DEVELOPMENT REVIEW BOARD

Project Number: PR-2022-007588

Project Name: New Mexico Cancer Center

Request: Amendment to Site Plan – DRB

E7 EAST ELEVATION
1/8" = 1'-0"

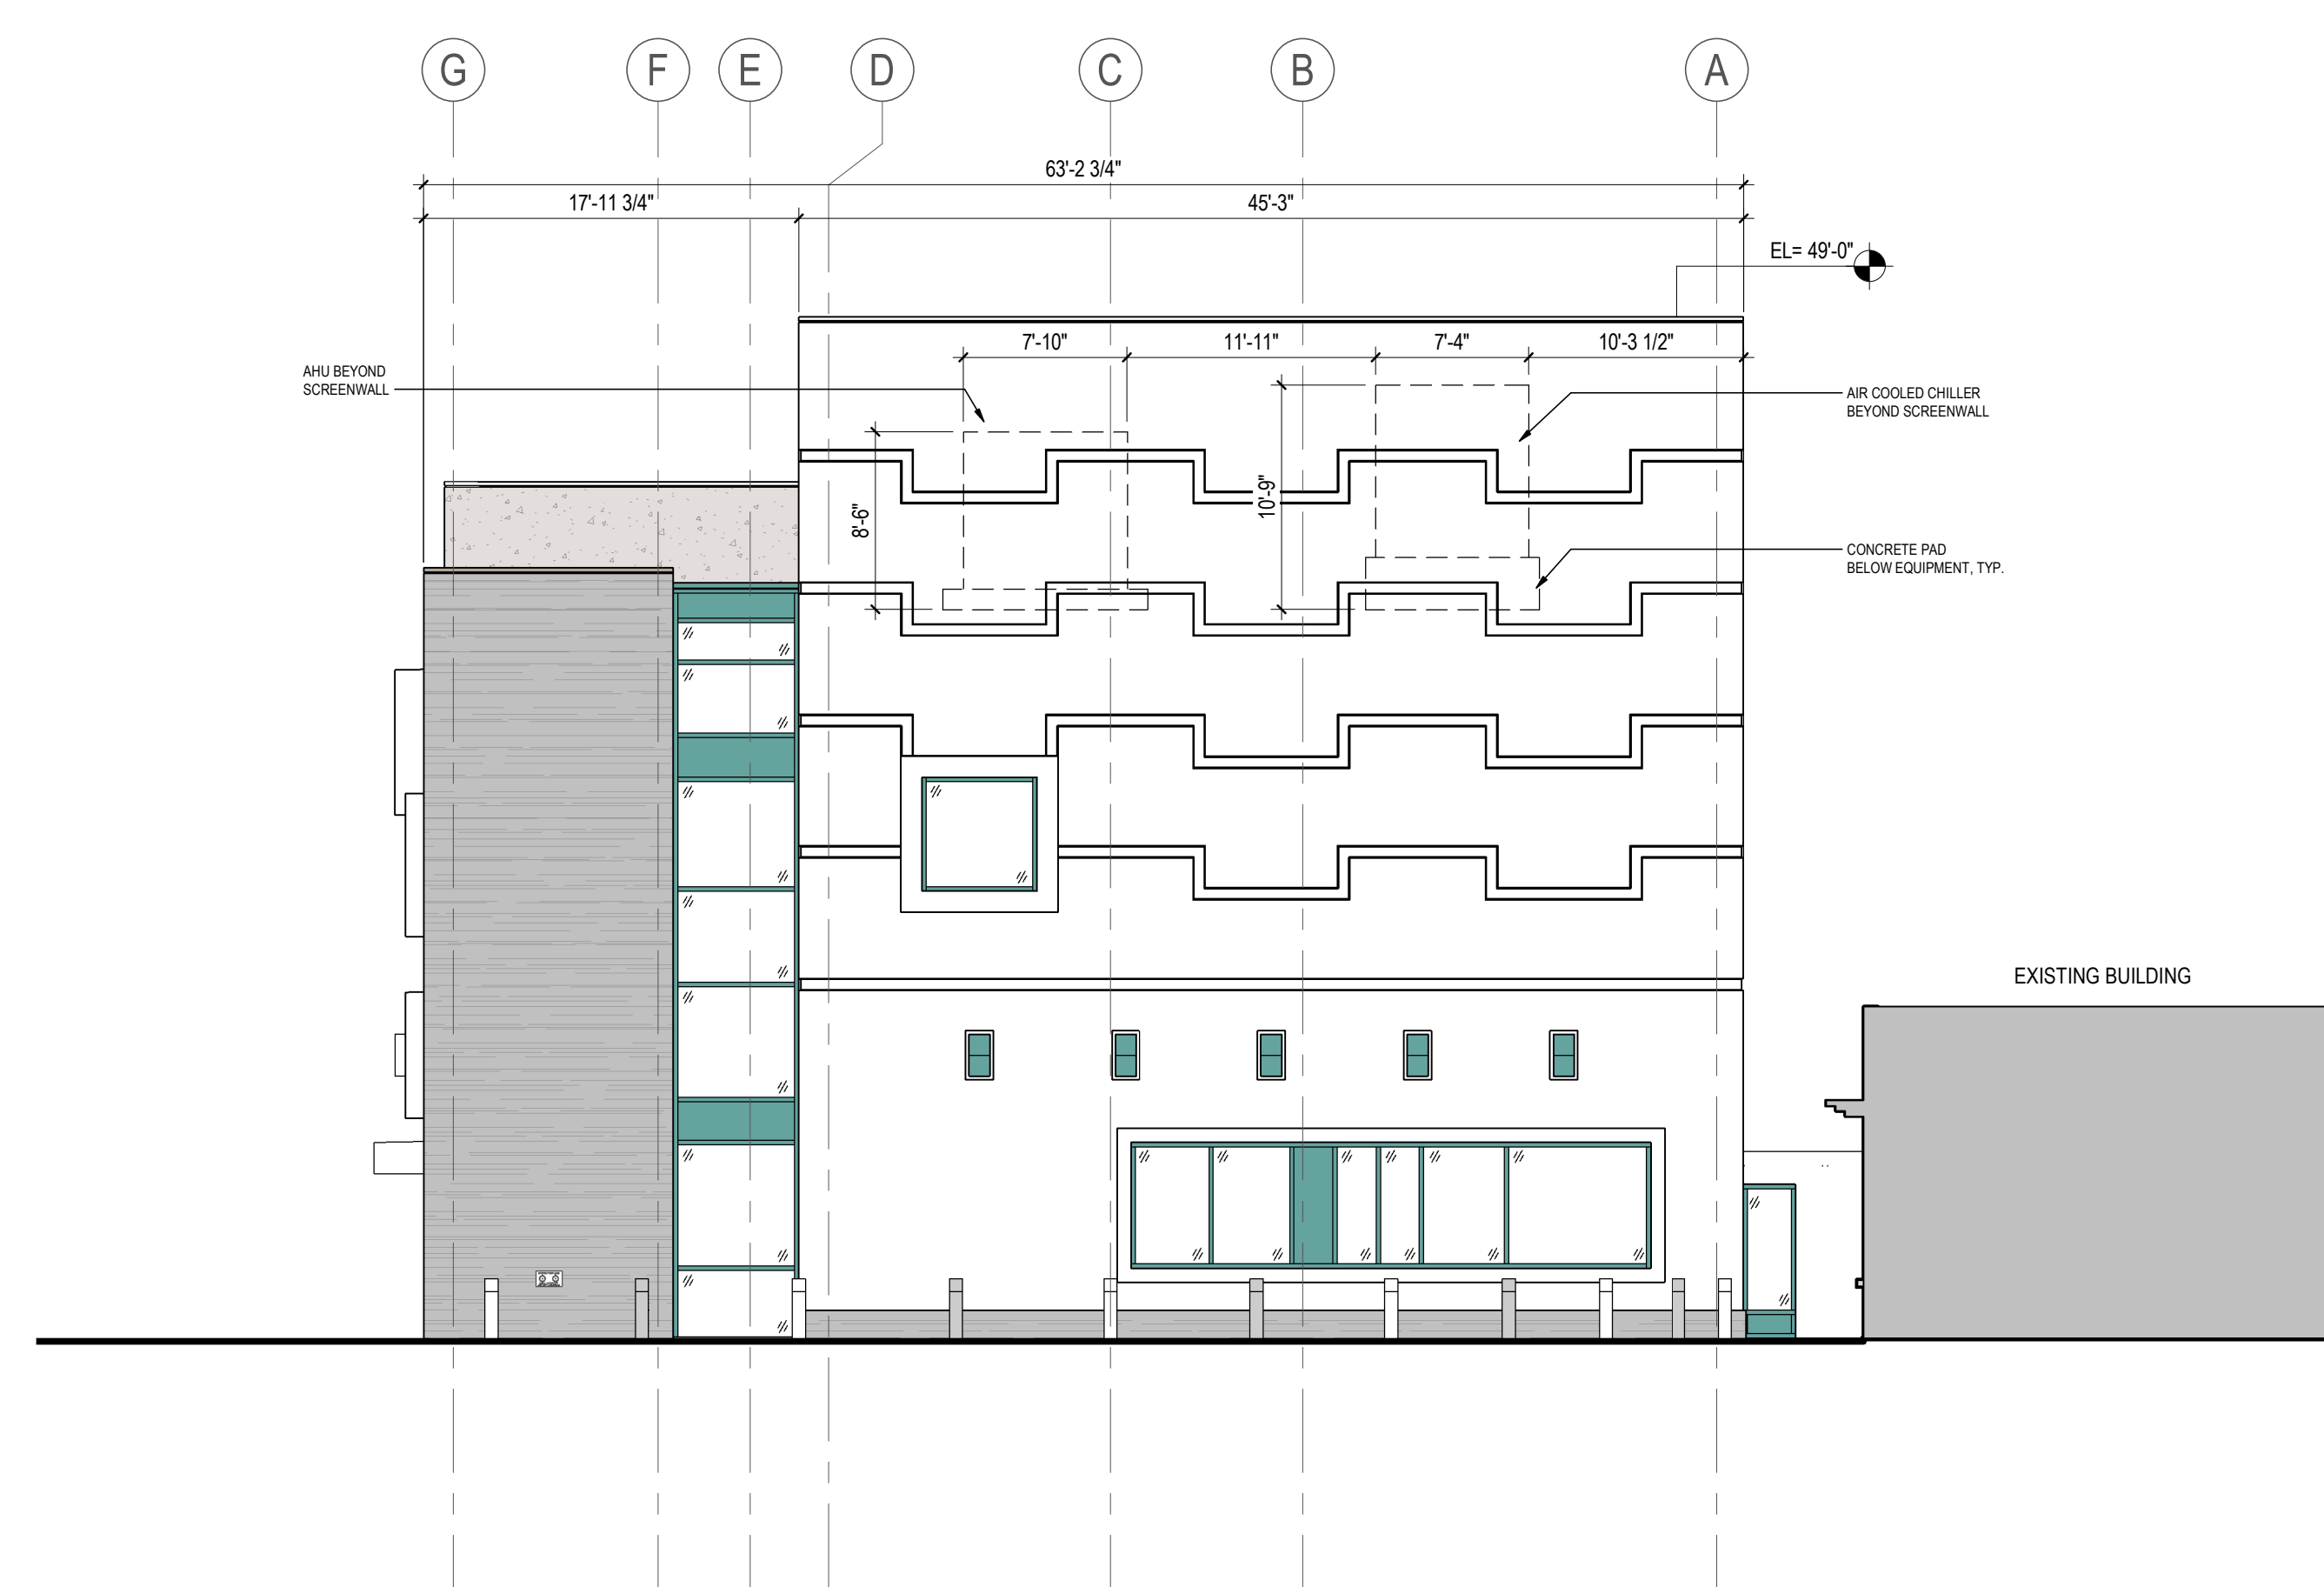
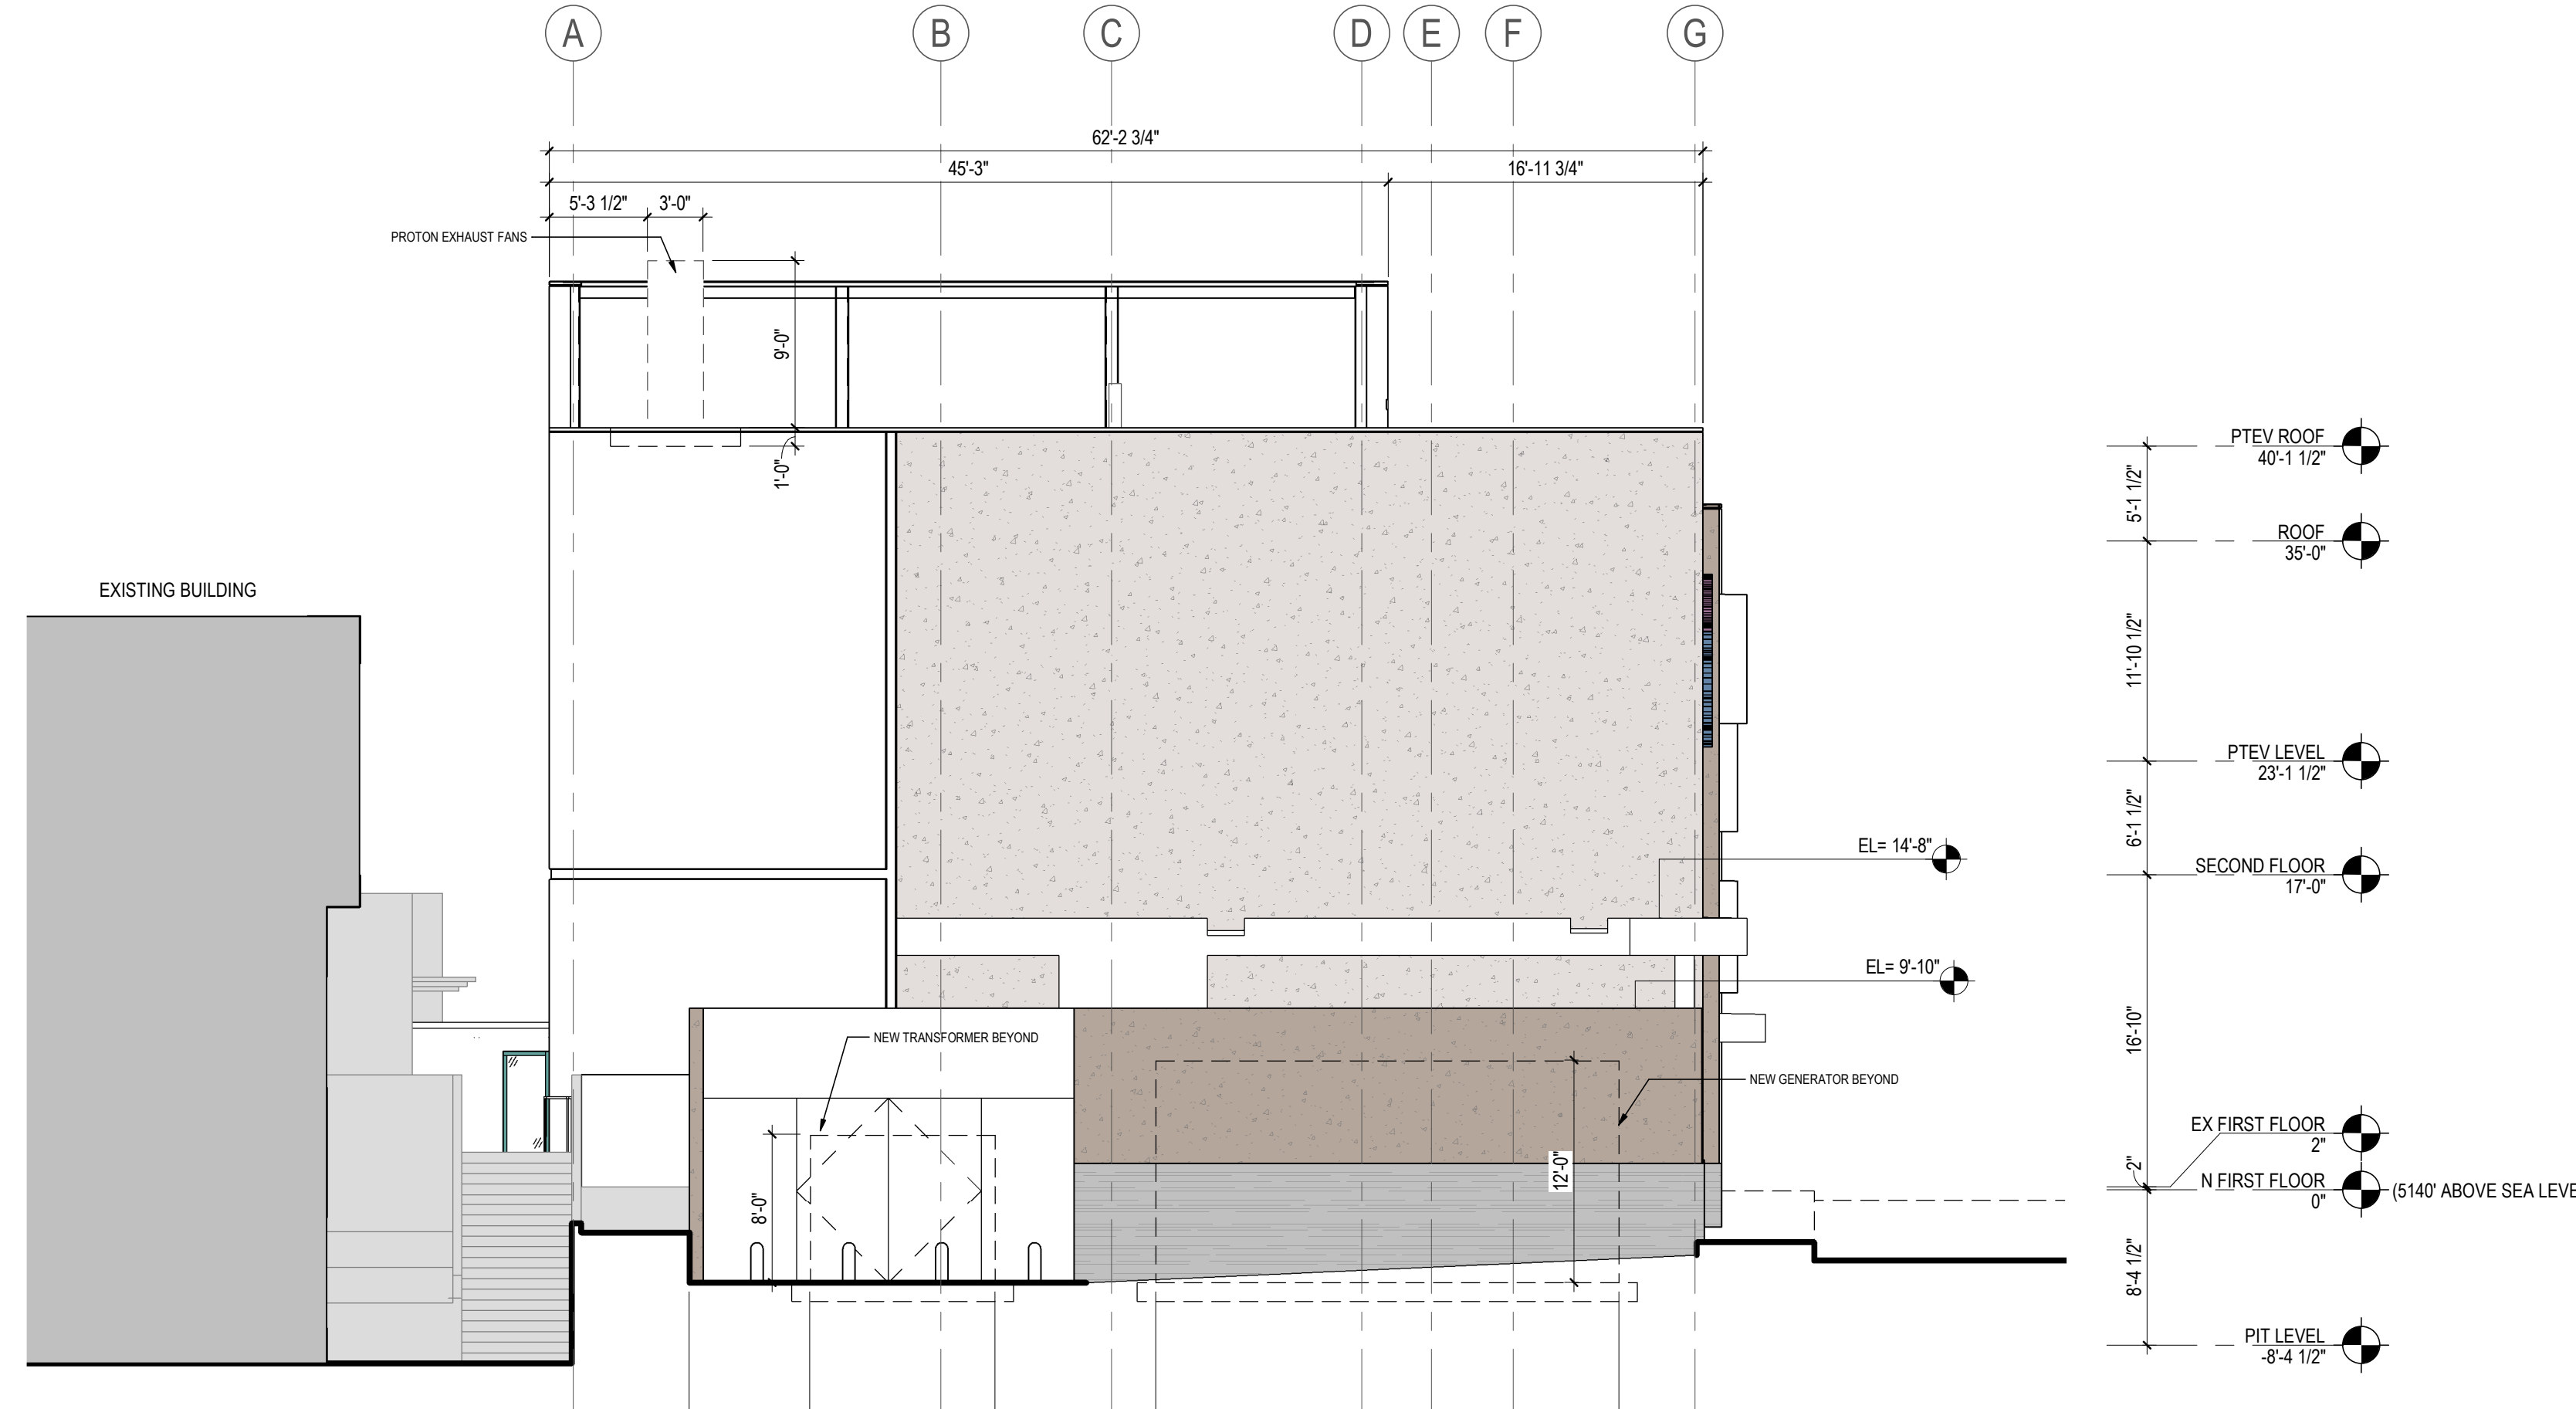
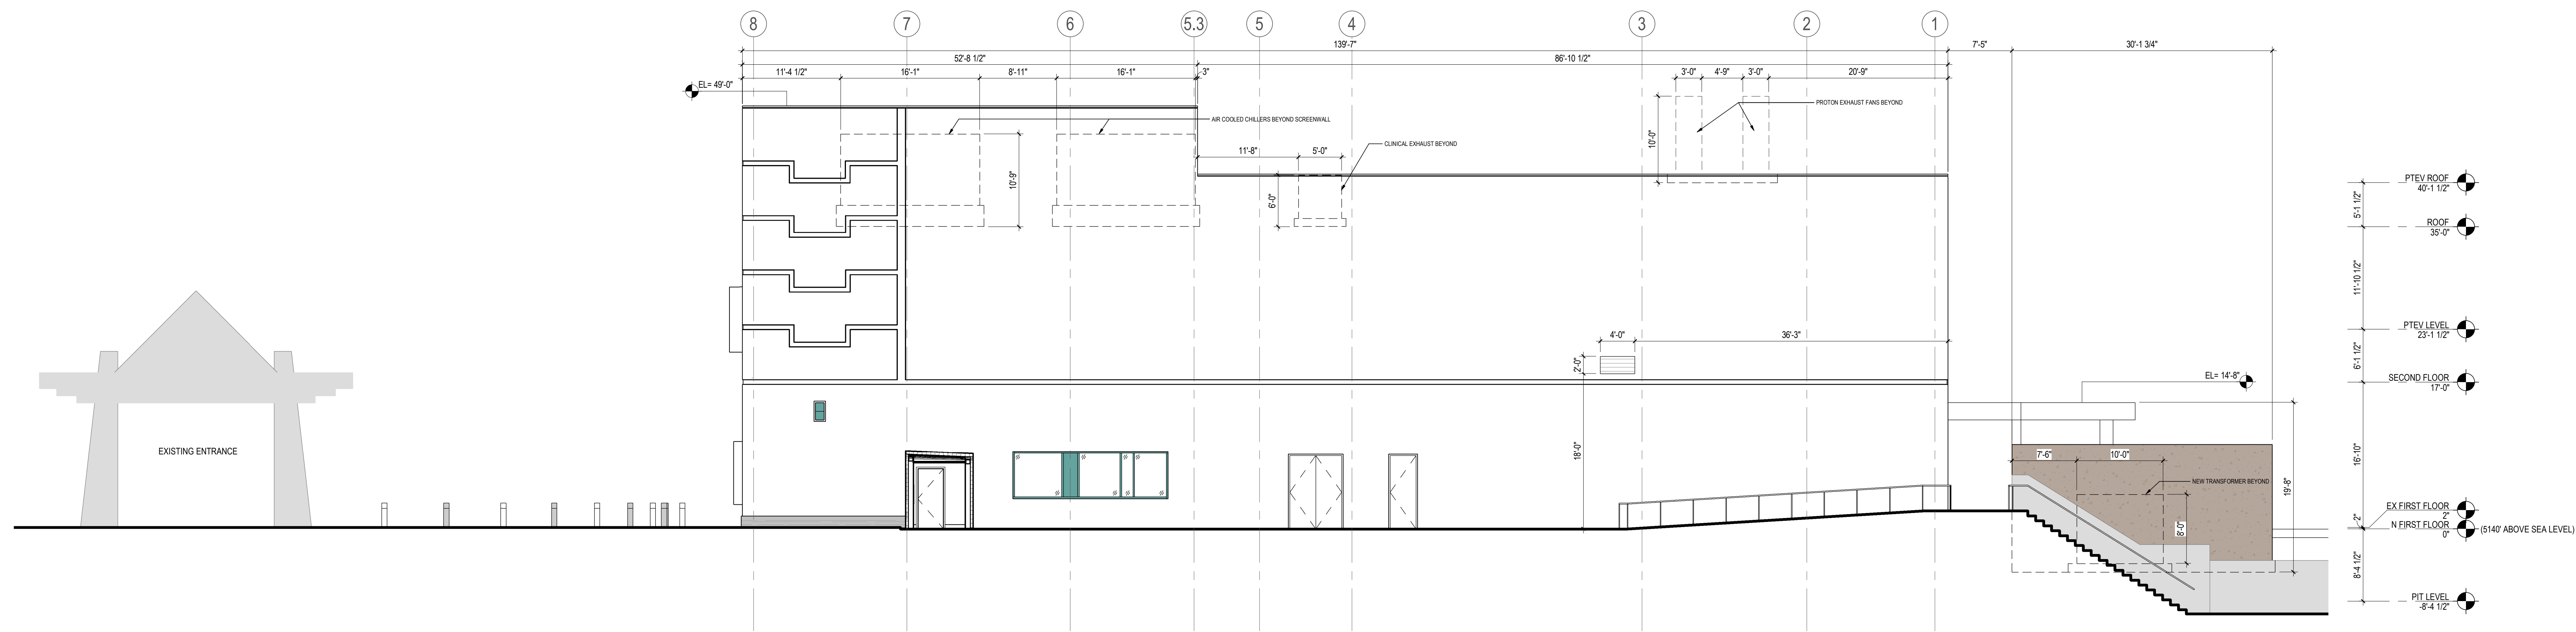
- The site is located within the Journal Center Master Plan. A letter of approval was received from the Journal Center Architectural Review Committee approving the proposed development. Staff needs more information on the façade to determine compliance.

- The applicant must provide proof how the building/façade design requirements are being met per 5-11(E) of the IDO as notes on the amended Site Plan and/or in a comment response letter.
